Sent: Friday, September 13, 2024 10:21 AM
To: DC Admin <DC.Admin@kirklees.gov.uk>
Cc: Molly Storer <Molly.Storer@kirklees.gov.uk>
Subject: OBJECTION Application 2024/92024 - 14 Bankfield Terrace

Application 2024/92024 - 14 Bankfield Terrace
Erection of a single storey side extension and alterations.

Plans - Proposed Ground Floor Plan

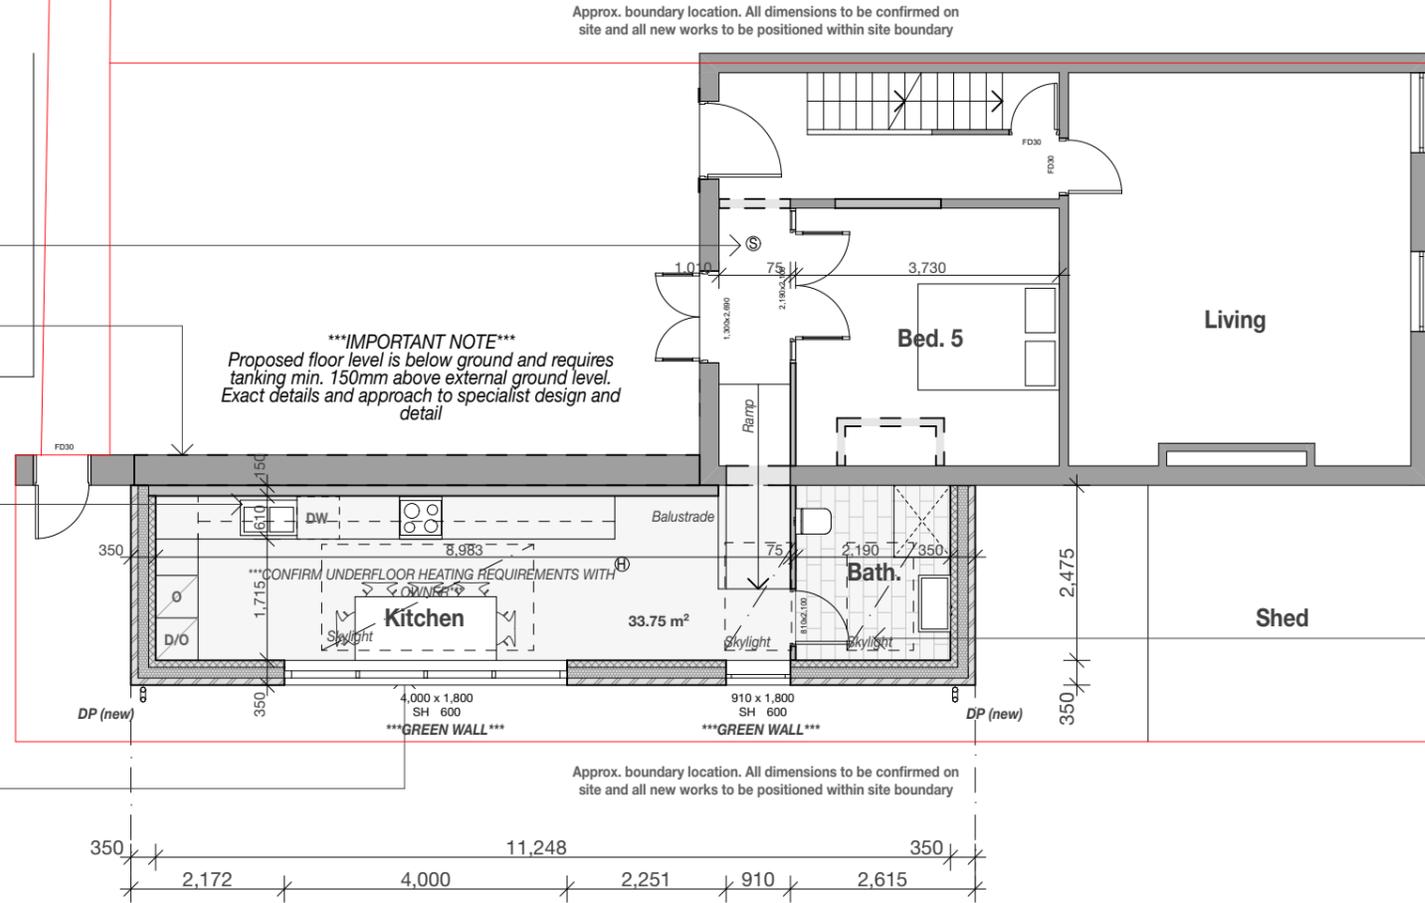
Despite the removal of the bi-folding doors and reduction in height, the substantial massing of the extension remains a significant concern. There appears to be a window to the outward facade and the extension still extends considerably beyond the building line. As the immediate neighbouring property, no. 16, along with other properties on the terrace are very likely to feel 'hemmed-in' by the extension dominating the small area of space left on the Bankfield Terrace.

Site Plan - Proposed

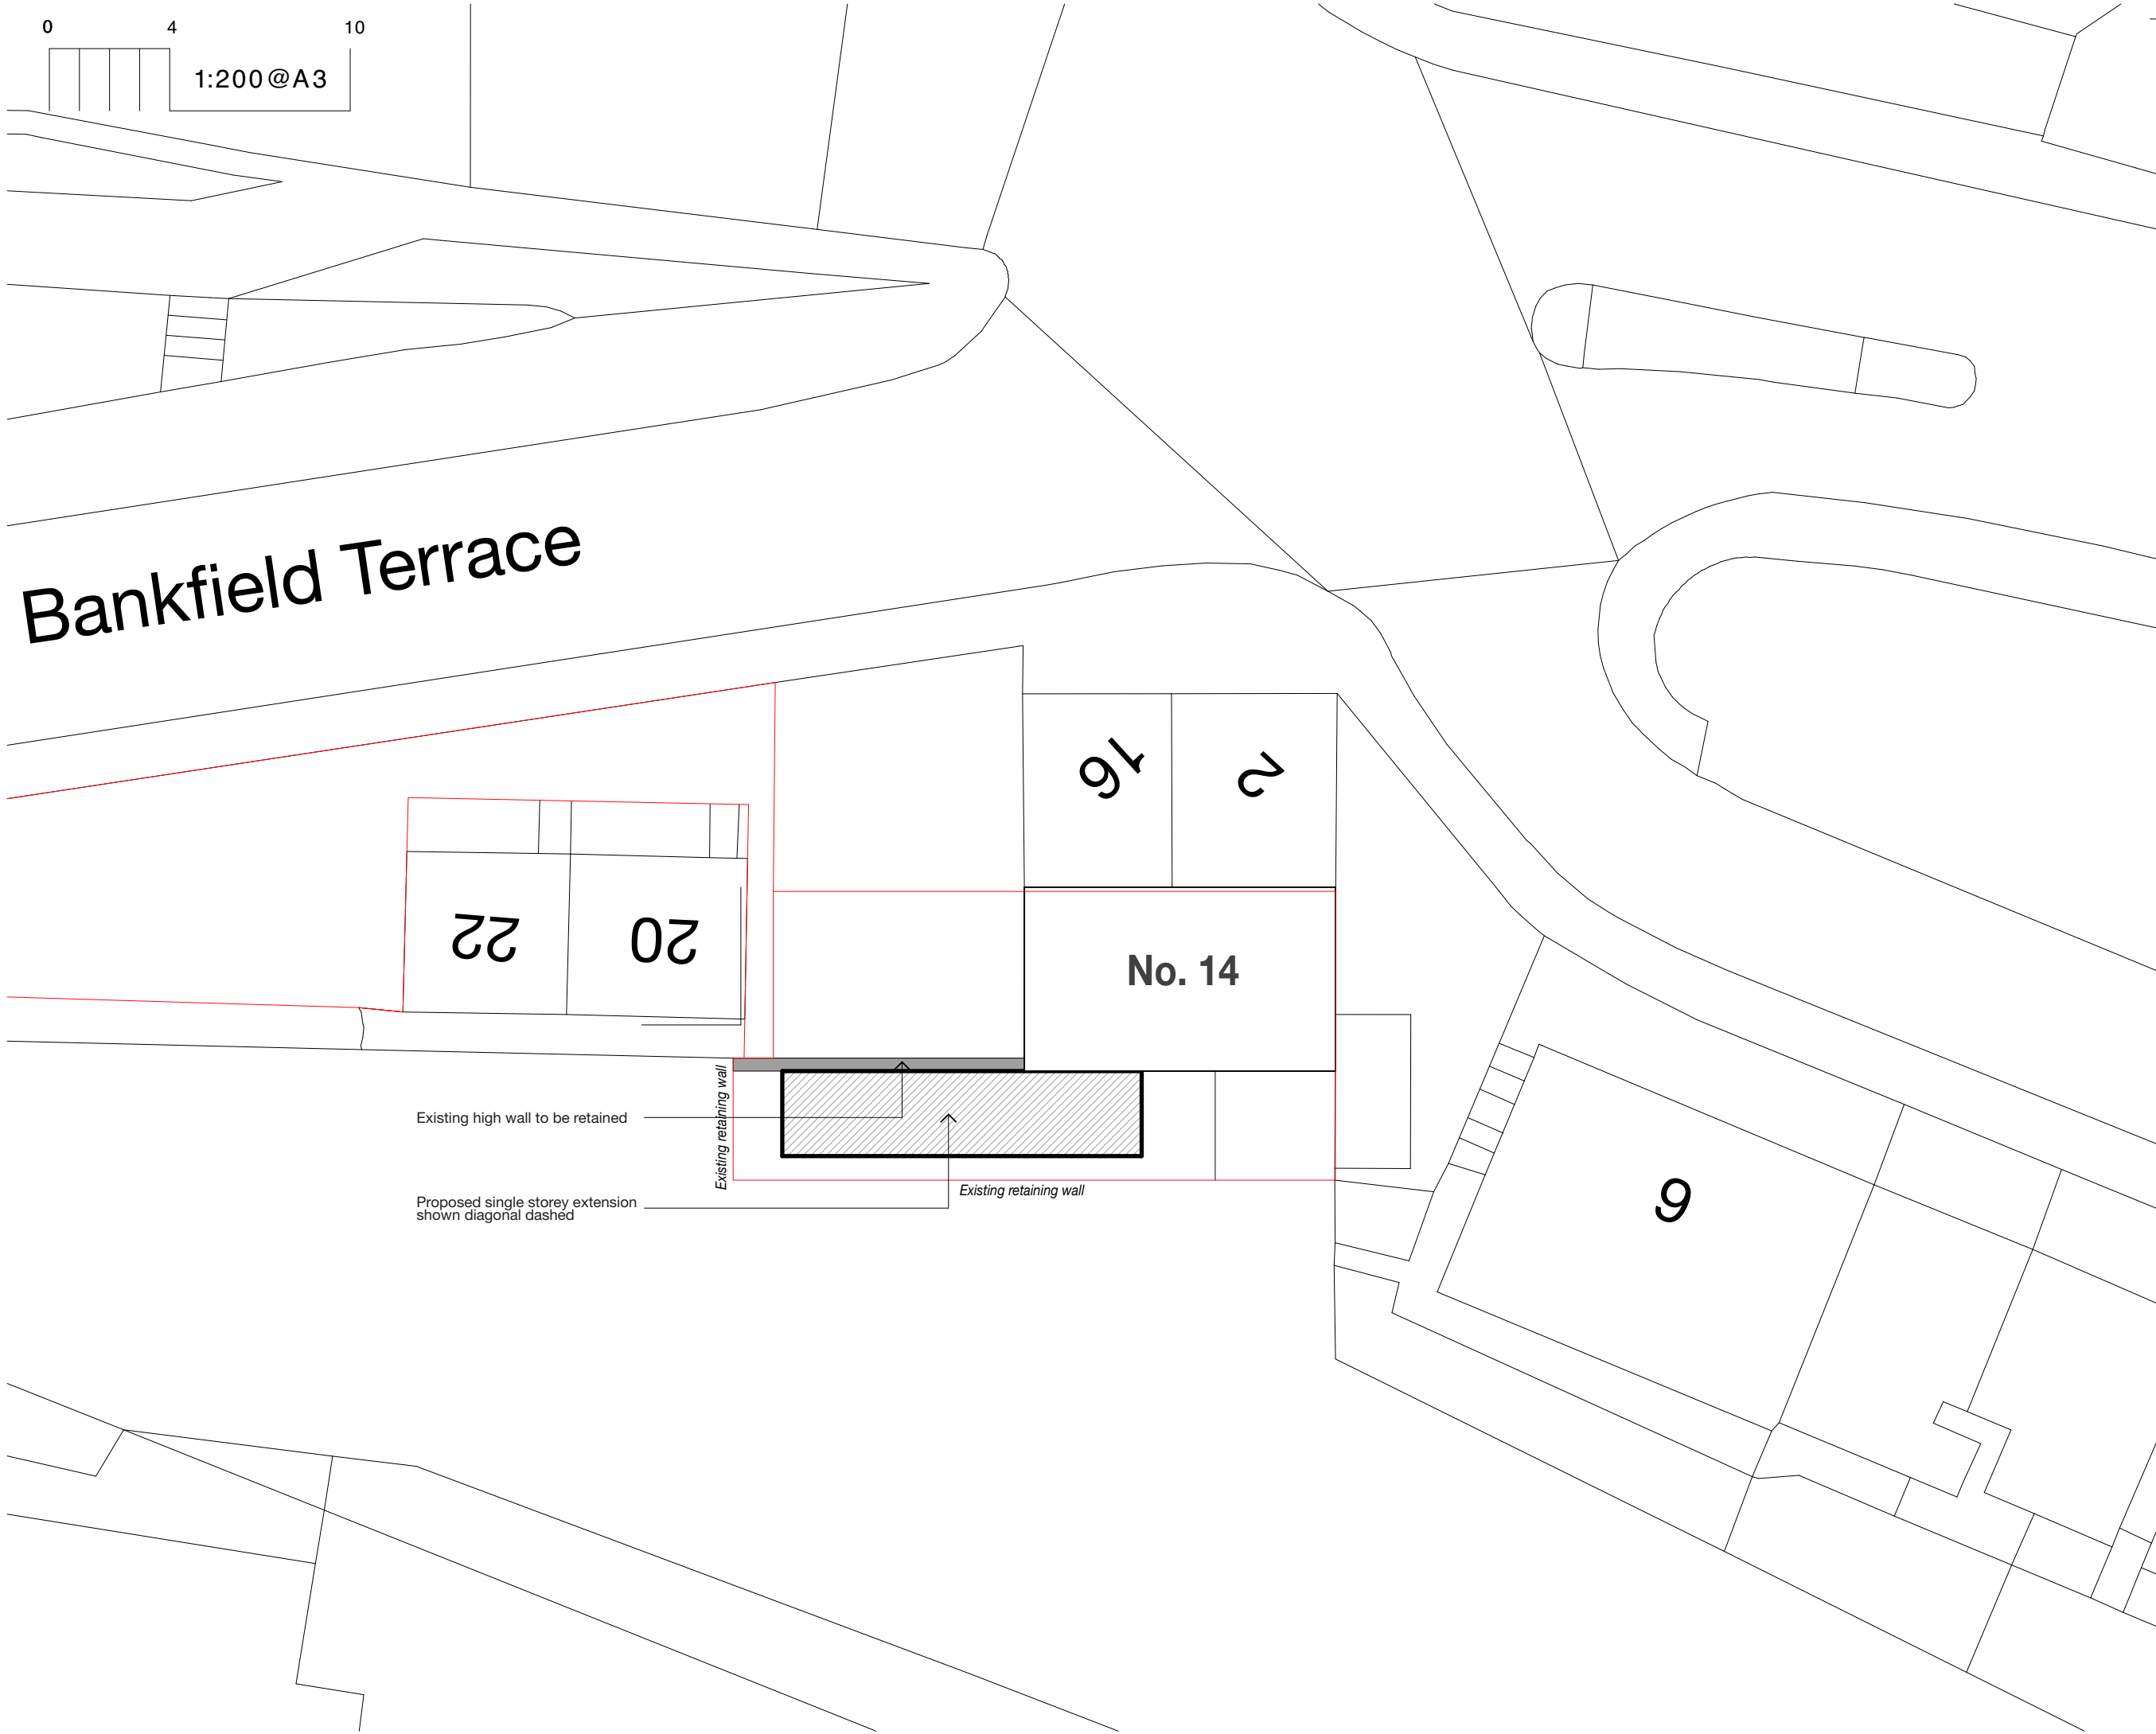
There have been historic stability issues with the retaining wall adjacent the proposed extension site, including a previous collapse. The planning application documents do not adequately address these concerns. There are fears the retaining wall may collapse again, which is a safety risk to all residents of Bankfield Terrace. Additionally, the proposed green wall could exacerbate instability issues by adding extra weight. Any mitigation measures, such as buttresses, would further limit access and contribute to the overbearing nature of the scheme.
